Your ref:	145A Ashley Gardens	<b>Please reply to:</b>	<b>Phoebe Graham</b>
Our ref:	21/03658/FULL	Tel No:	07971 024216
		Fee Queries:	0207 641 6500;
		Email:	planningreception@westminster.gov.uk;
Ms Sarah Borowiecka Studio on the Rye Springbank Studio 81A Grove Park London SE5 8LE		<b>Incomplete Applications</b> Development Planning City of Westminster PO Box 732 Redhill, RH1 9FL	
		4 June 2021

**Address: 145A Ashley Gardens, Thirleby Road, London, SW1P 1HN,**

**Proposal: Installation of double glazed timber windows and doors, including removal of vent grilles from the glazing and installation of one vent grilles to the lightwell elevation.**

D1240

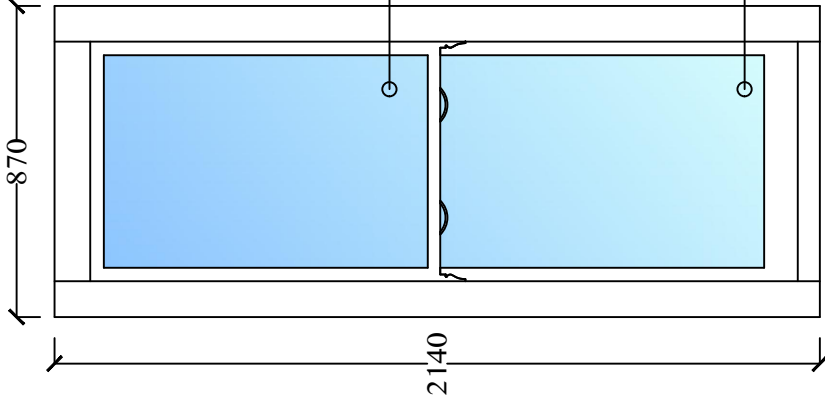
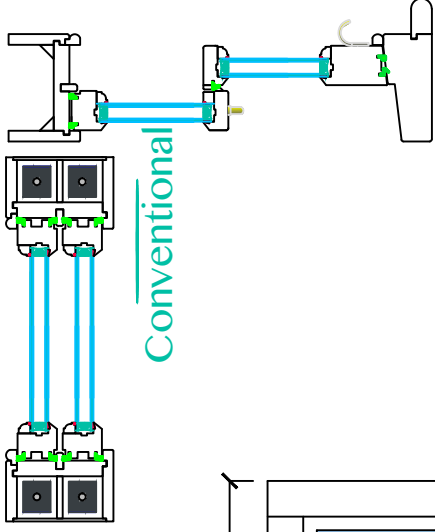
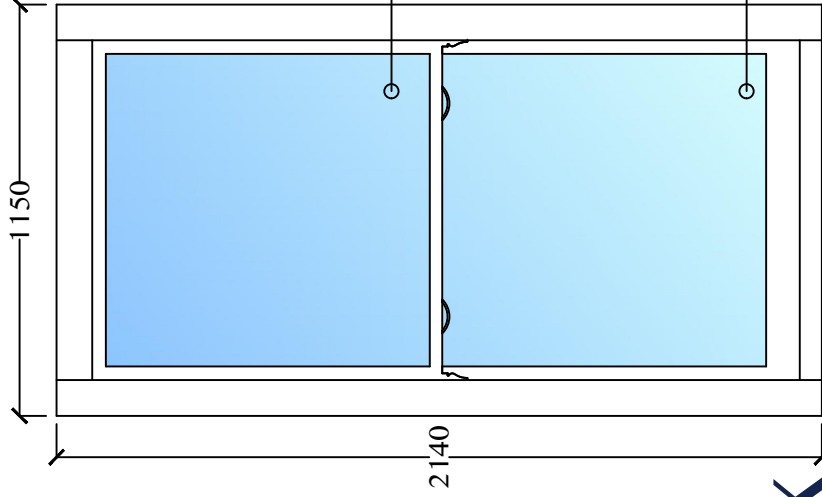
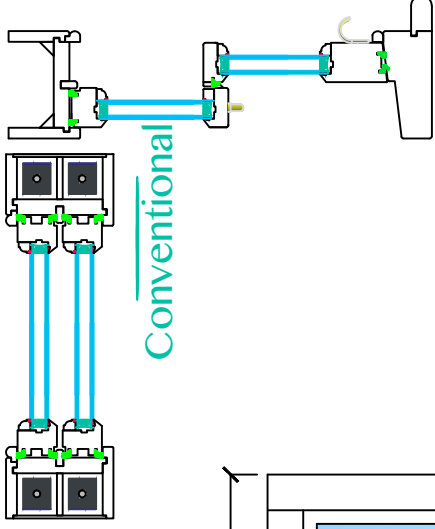
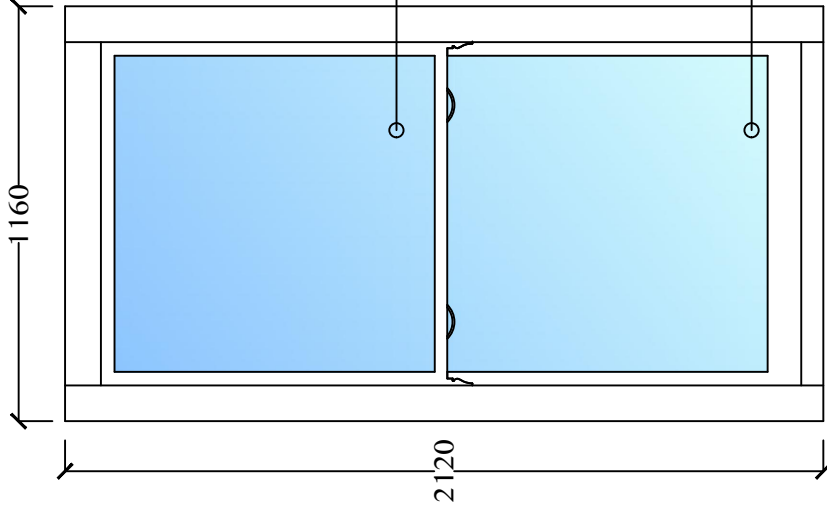
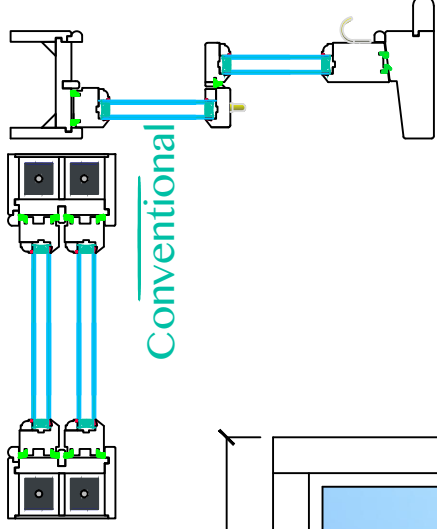
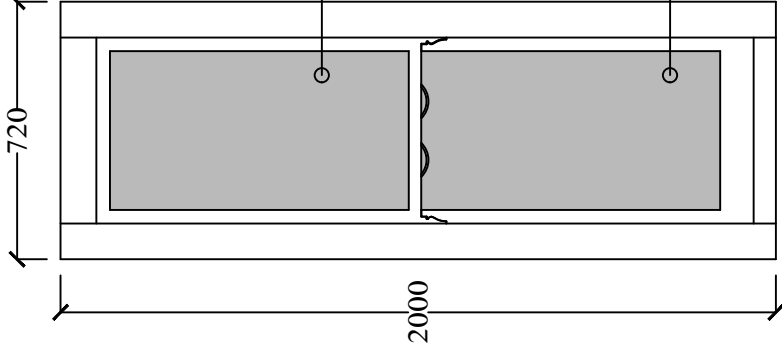
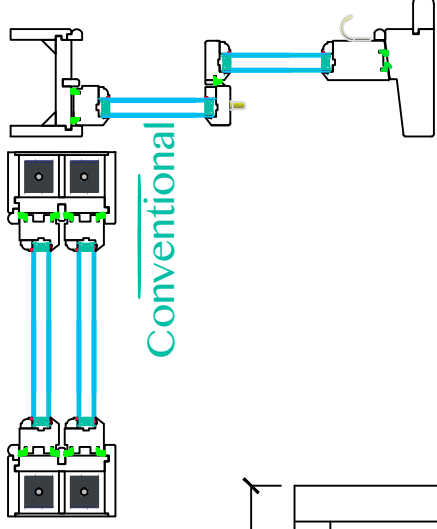
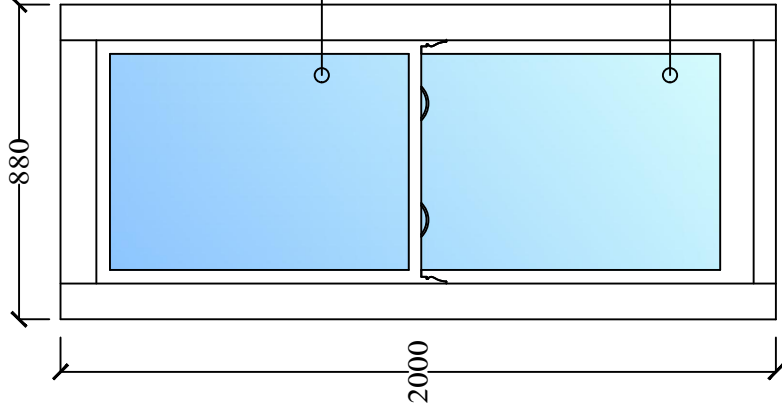
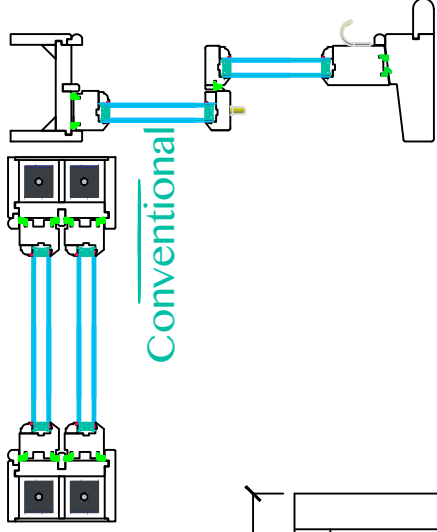
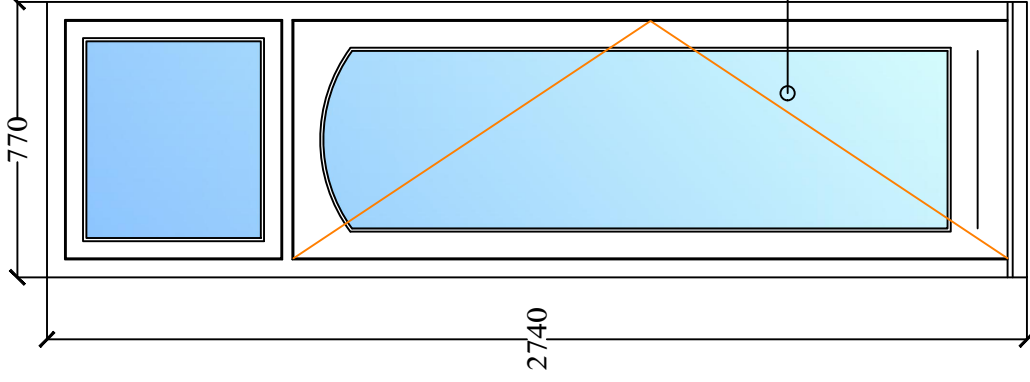
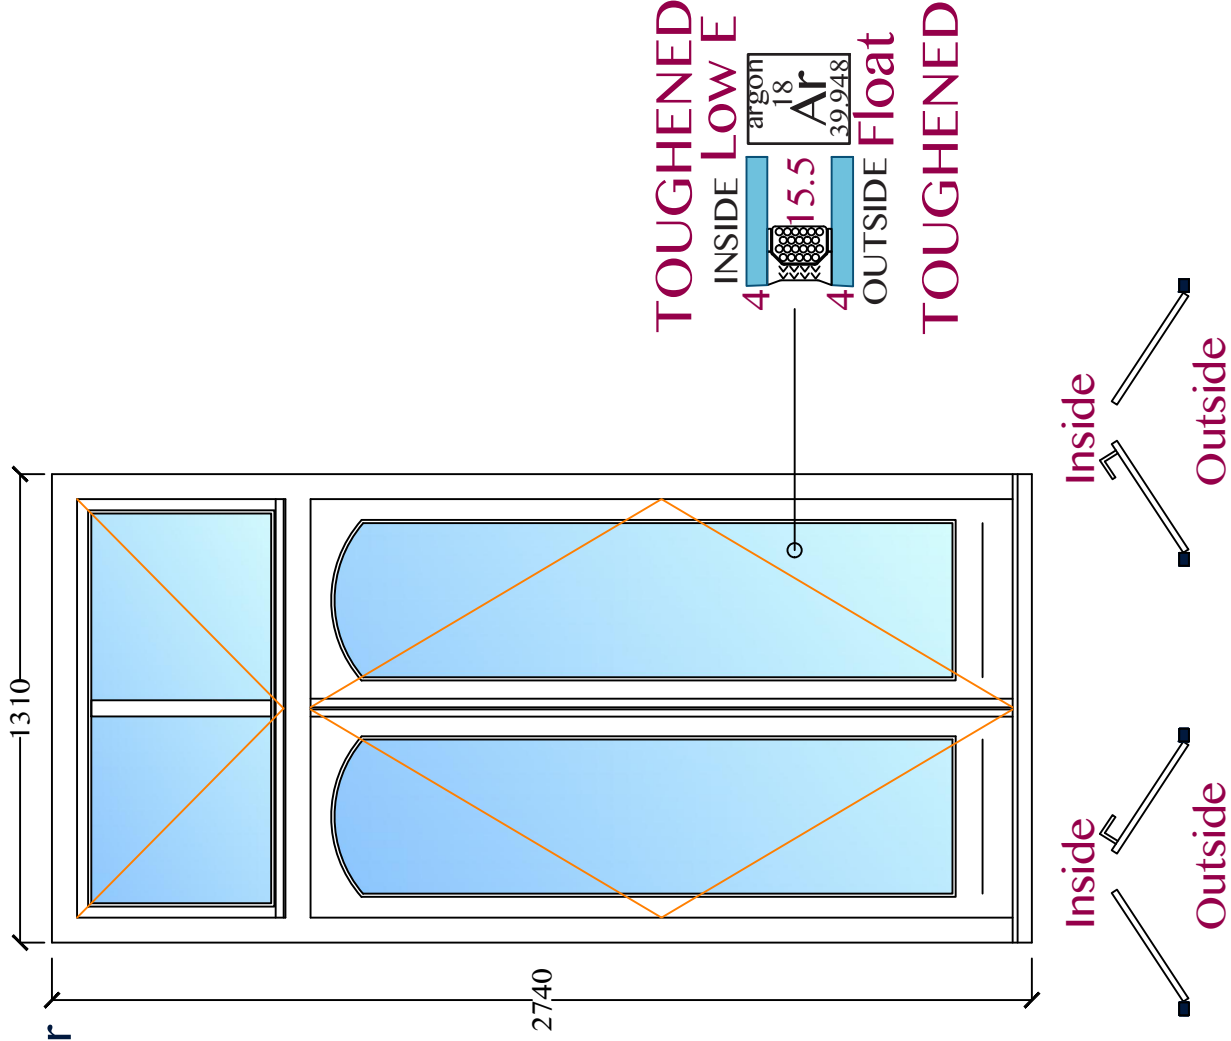
- 1 Some or all of the drawings submitted with your application do not include a scale bar, please amend. This is required as we have moved to an electronic way of working and no longer print paper copies of drawings.
- 2 Please ensure the window details are labelled to show which details are for which window.
- 3 You have completed the Householder application form. However, the site appears to be a flat. If this is the case, you need to complete a Full planning application form. You are advised that the fee may change as a result of the new application type. Please refer to our website for details.
- 4 You have completed Certificate B, but only one owner/agricultural tenant has been
